Subject: FW: Incomplete Letter for case 21/05234/PNX at Crook Farm

the proposed outbuilding subject of a separate application.

Client: Mr & Mrs D Flannery	
Project: Crook Farm Ox Close Lane North Deighton LS22 5HW	
Drawing: Proposed Site Layout	
Date: June 2021	Scale: 1:1250, 1:200@A3
Drawing No: 2081/110	Rev: B

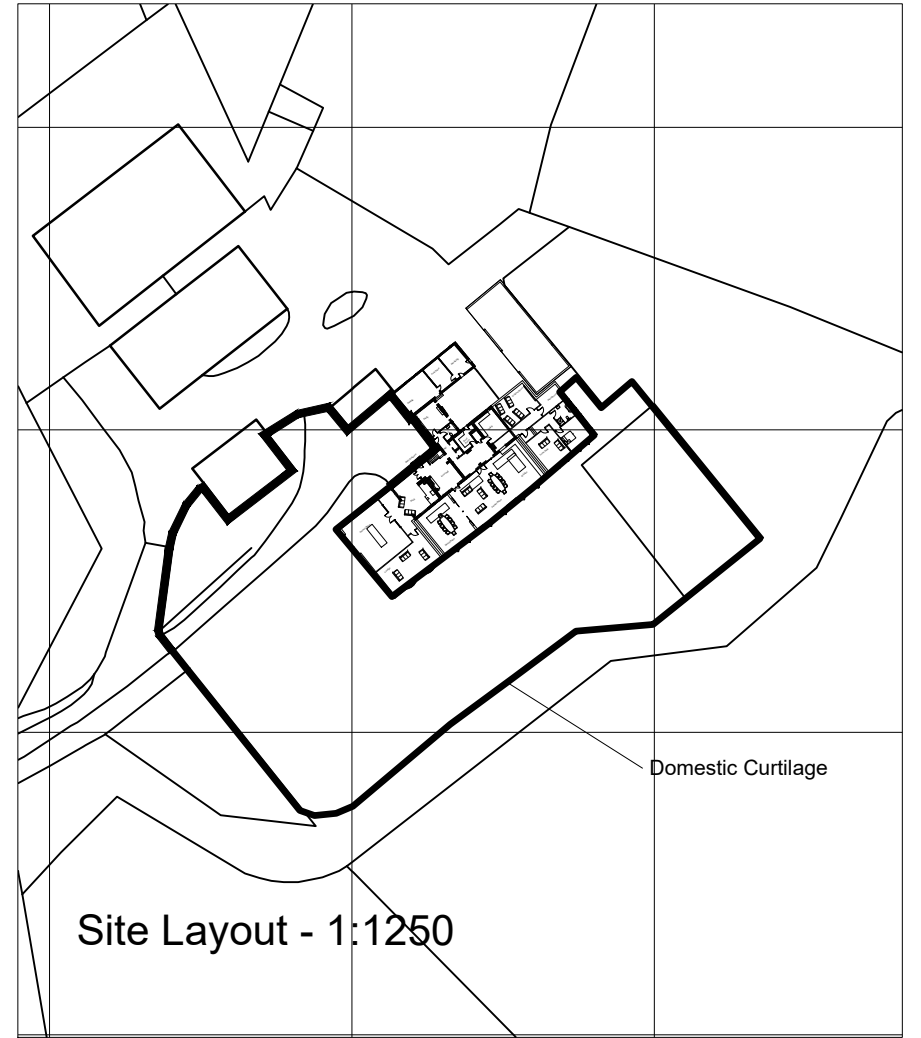
Further to our earlier discussion and this email please find amended site plans which do not show
